12 August 2010

**REQUEST FOR ADDITIONAL INFORMATION
THOMAS STREET CAR PARK MP09_0066**

We write to you on behalf of the applicant, Welles Thomas, in relation to your email dated 23 July 2010 requesting additional information in relation to the proposed redevelopment of the Thomas Street Carpark, Chatswood. Our response is provided below, for ease of reference I have included your original comments (*italics*) with our response under each comment.

BASEMENT 1 PLAN

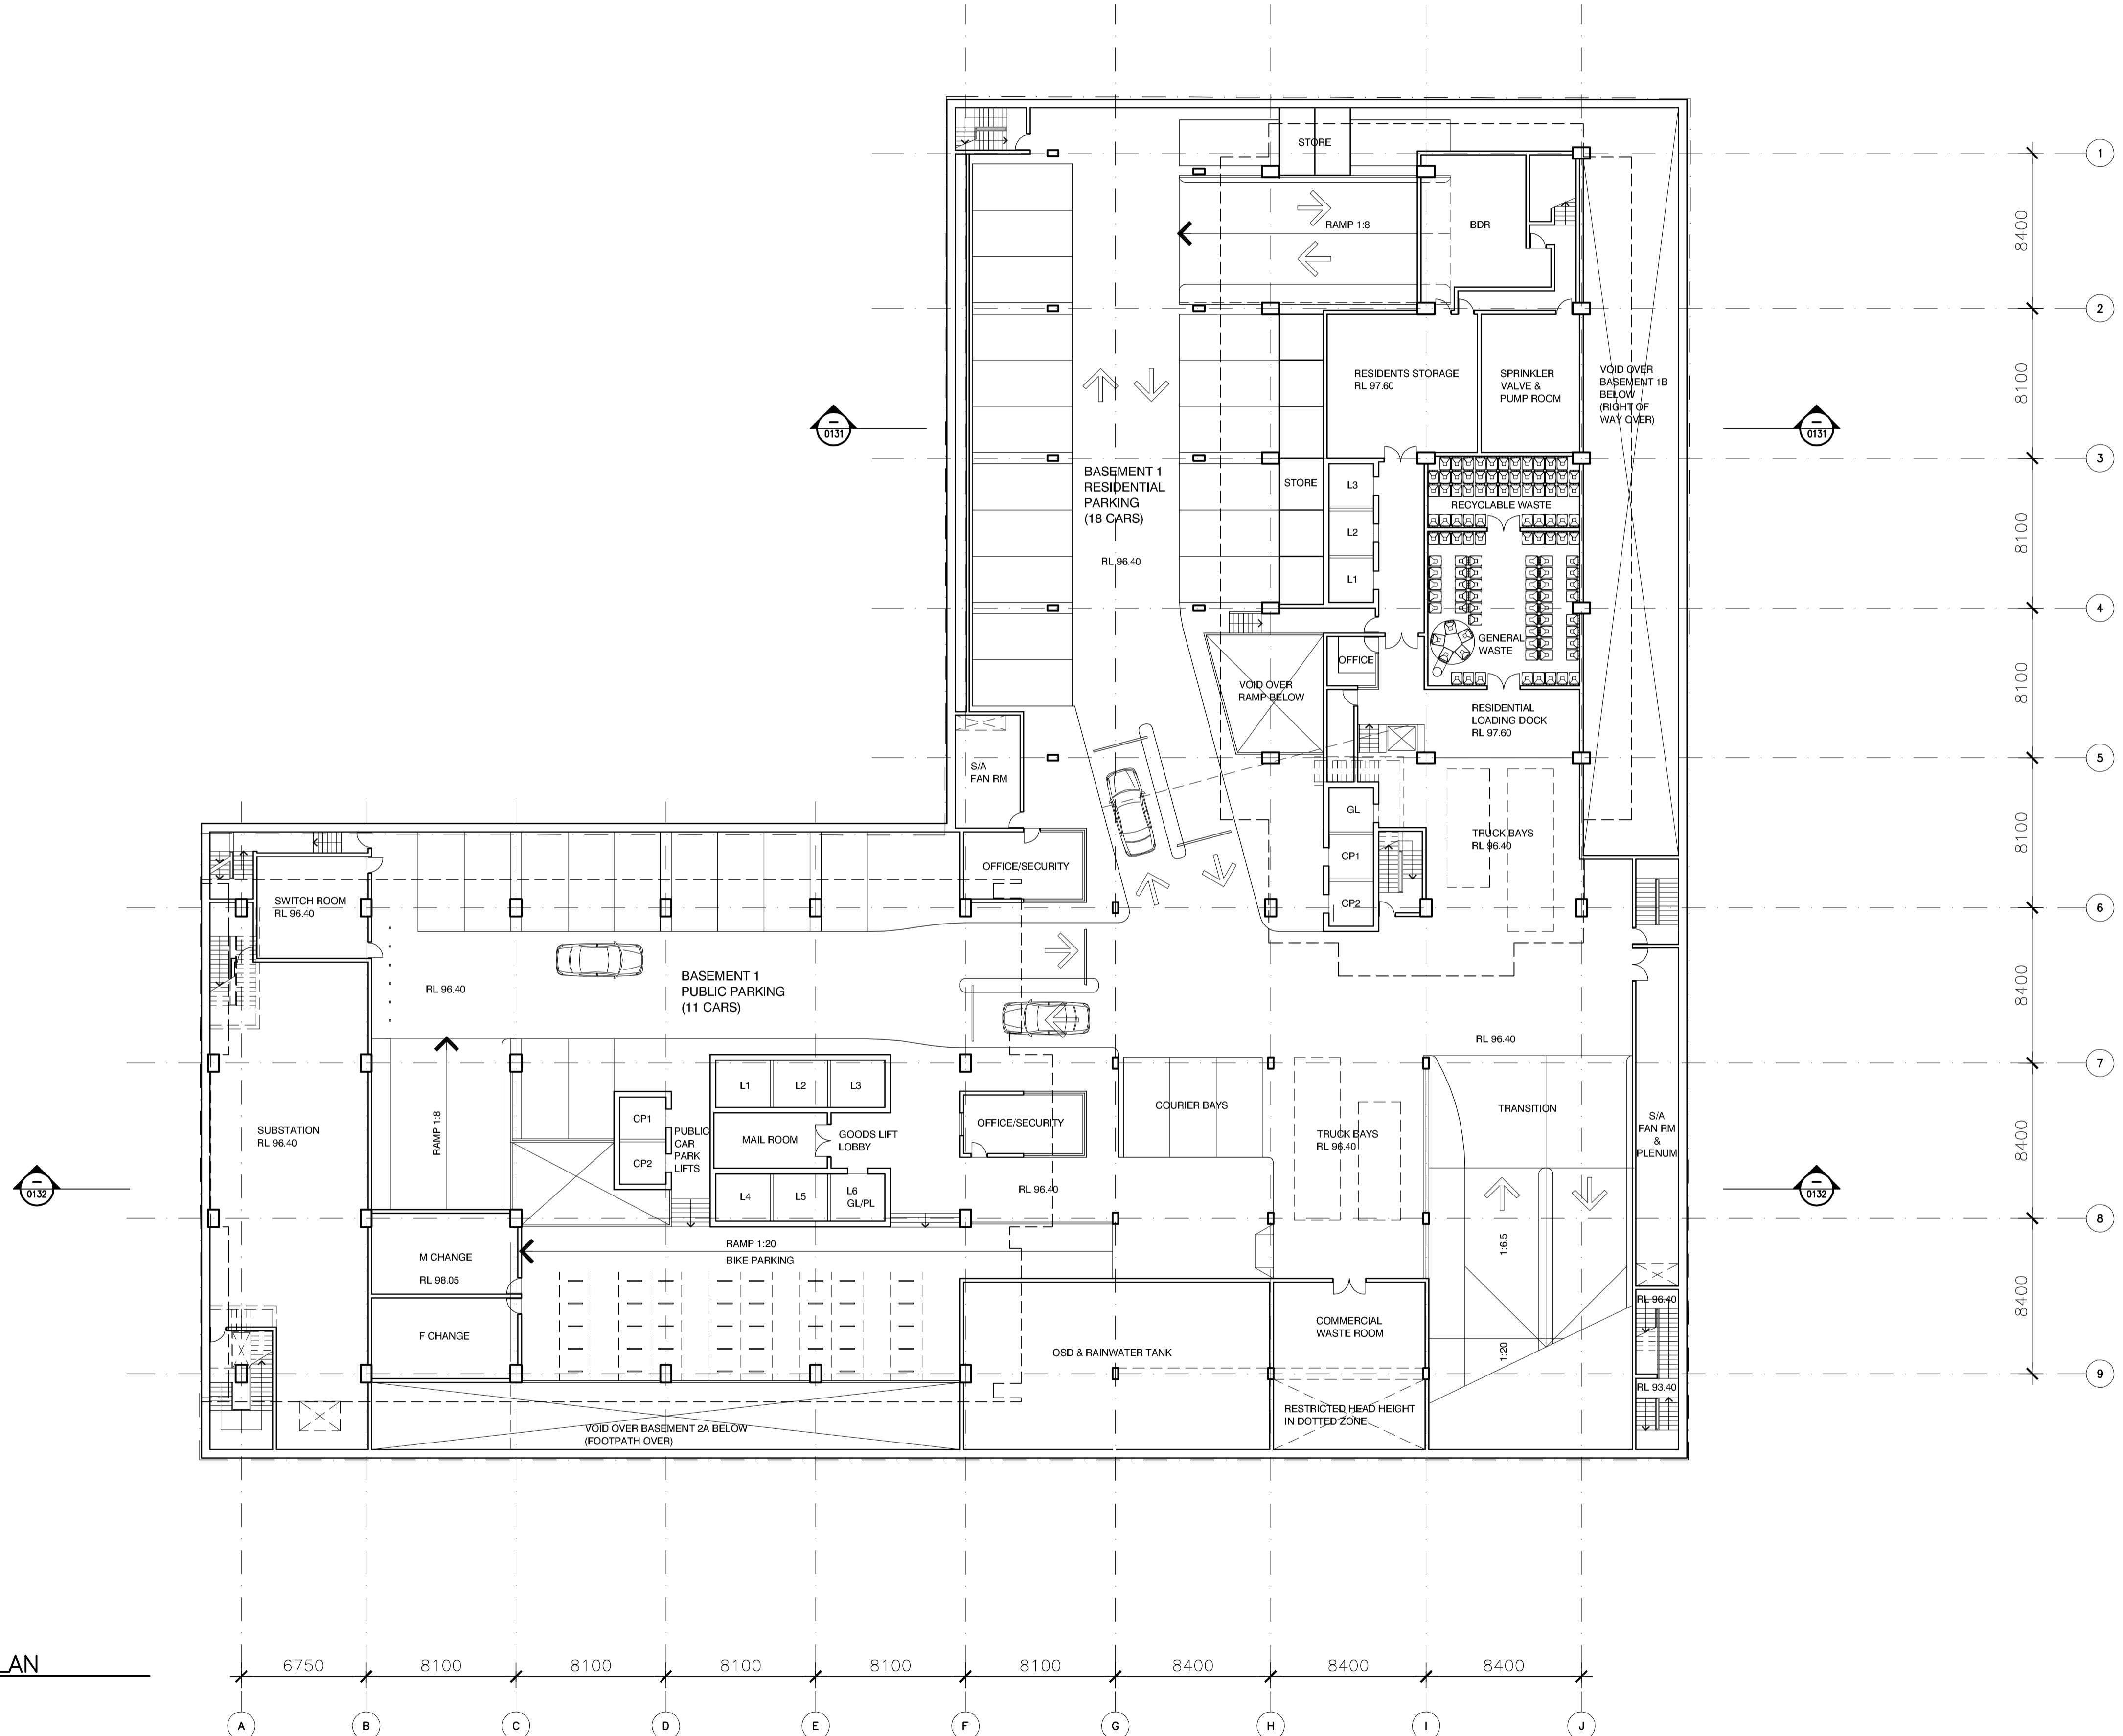
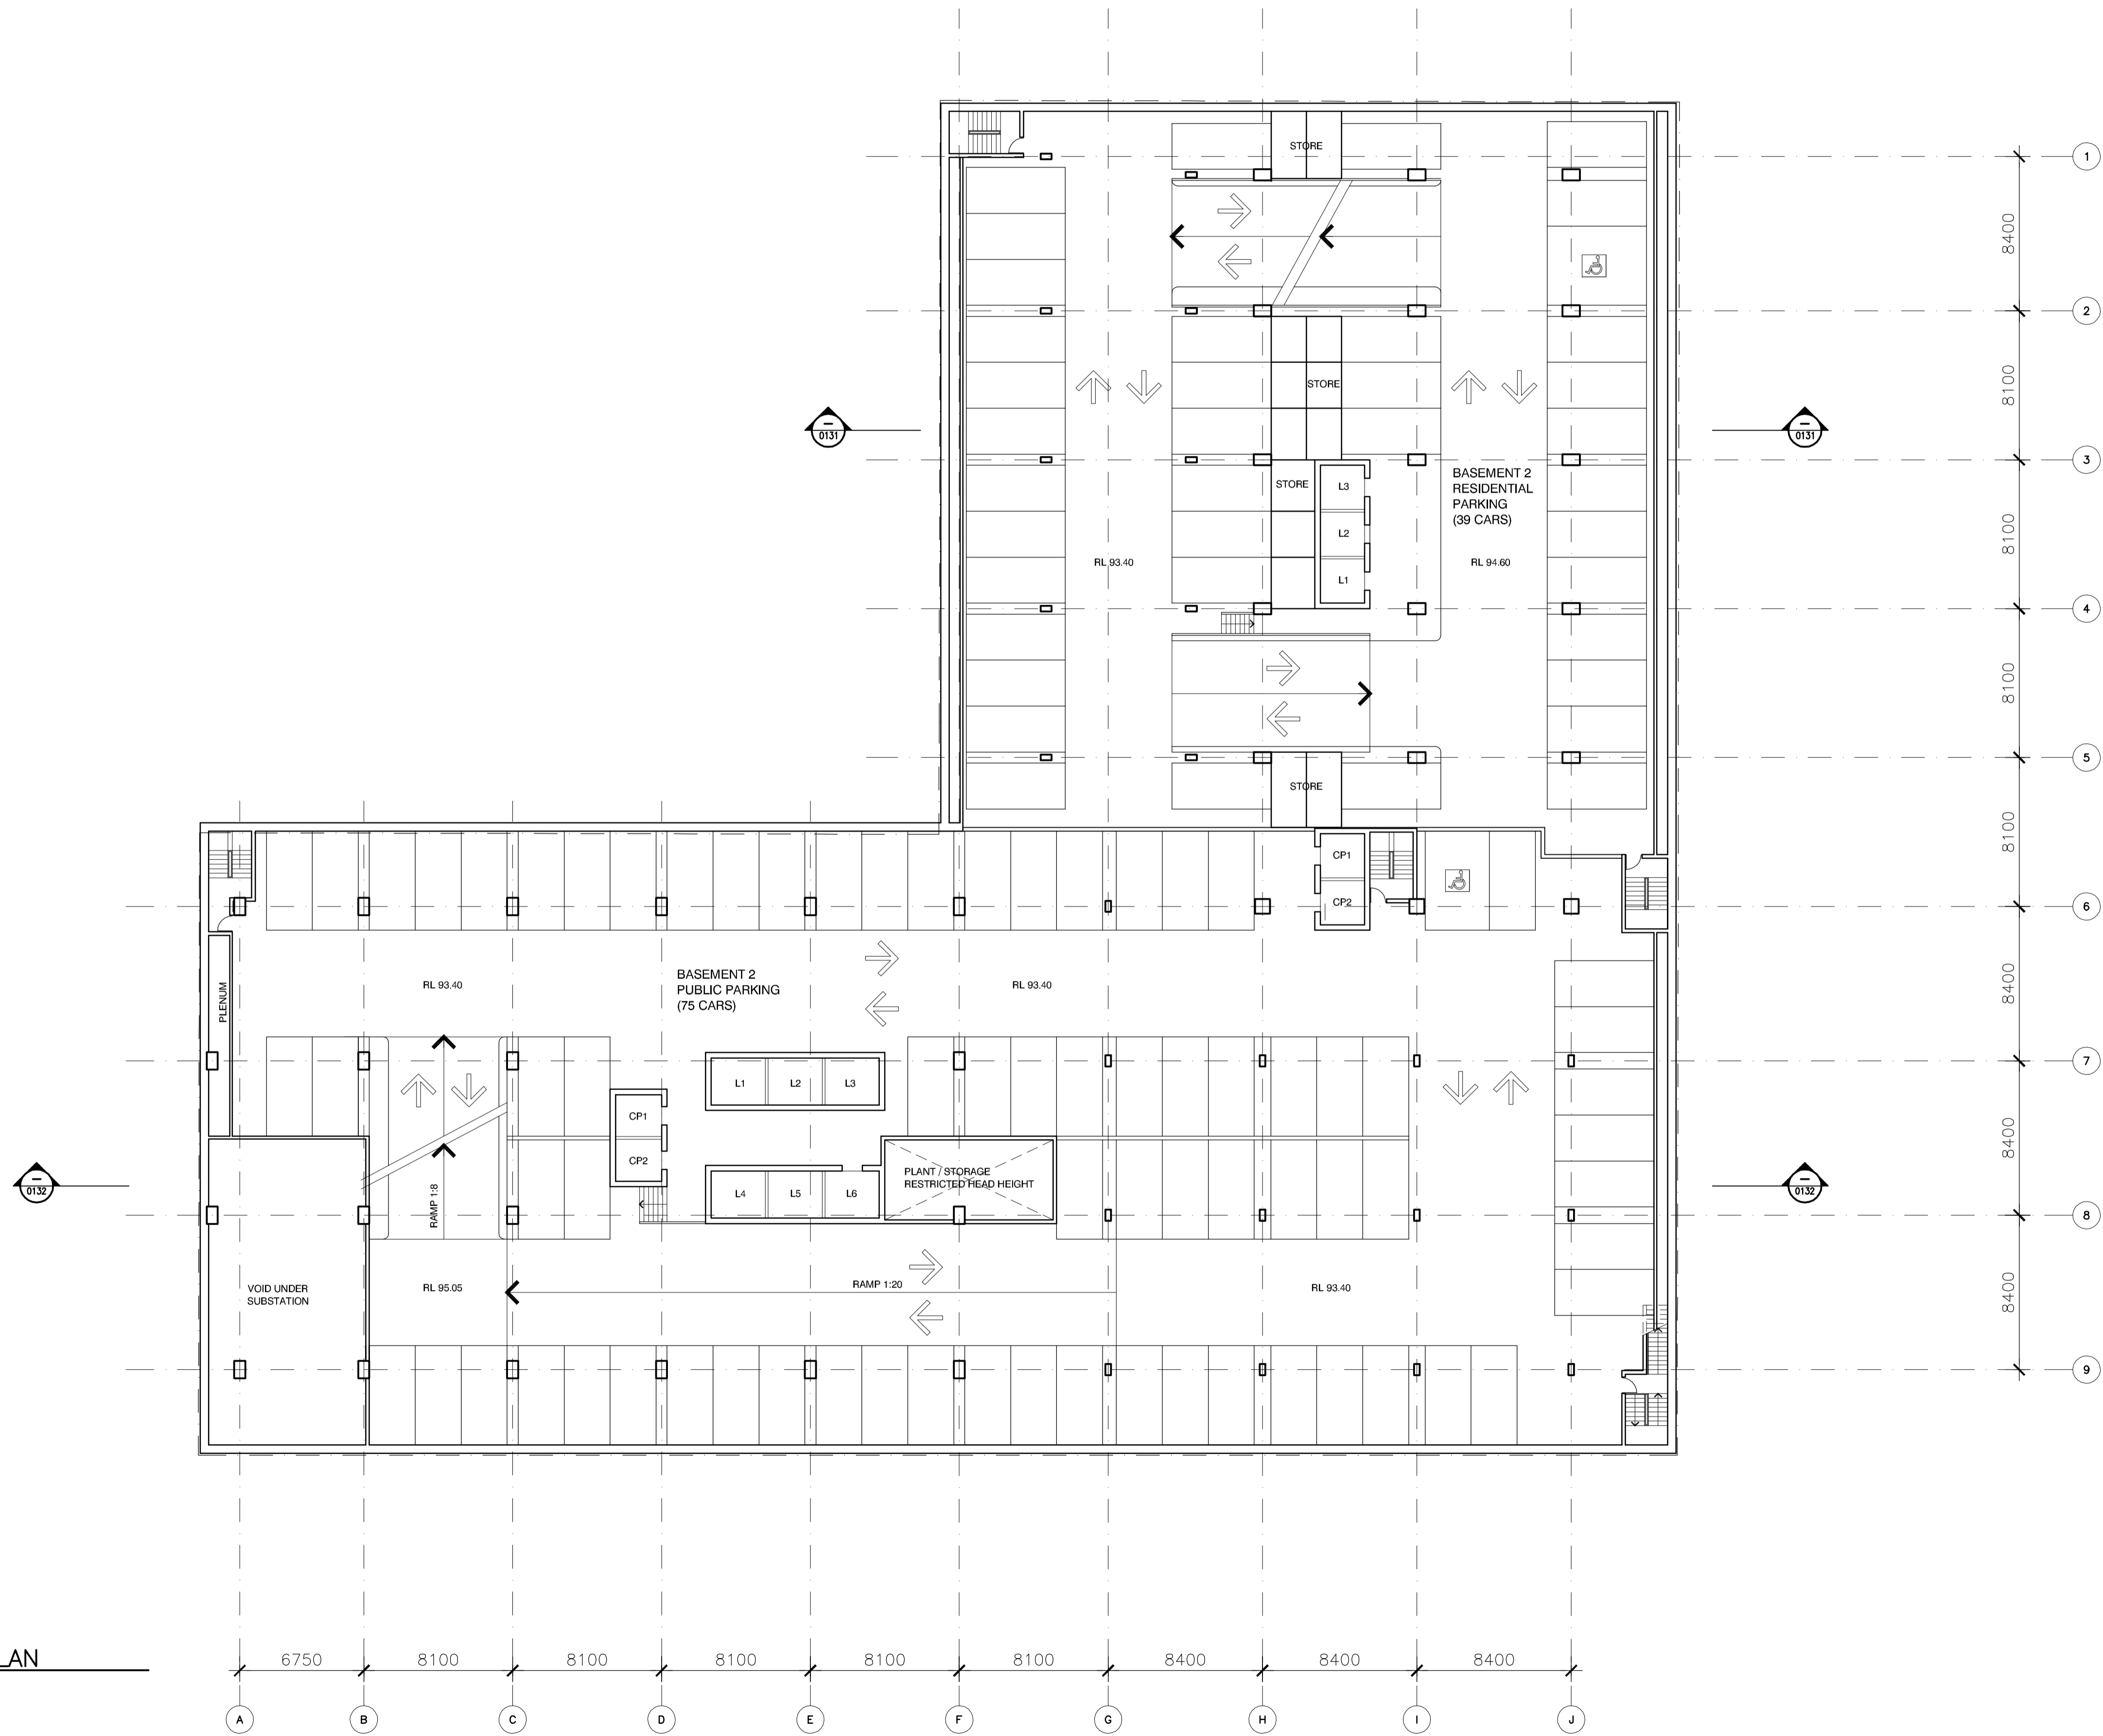
"The Department requests proper architectural plans drawn at an appropriate scale be submitted for any proposed modifications to the building layout."

Modifications to the building layout will occur below ground and will not have any impact on the operation or amenity of neighbouring property. It is requested that the Department of Planning impose a condition of consent requiring the submission of detailed architectural plans to the Department of Planning prior to the issue of a Construction Certificate.
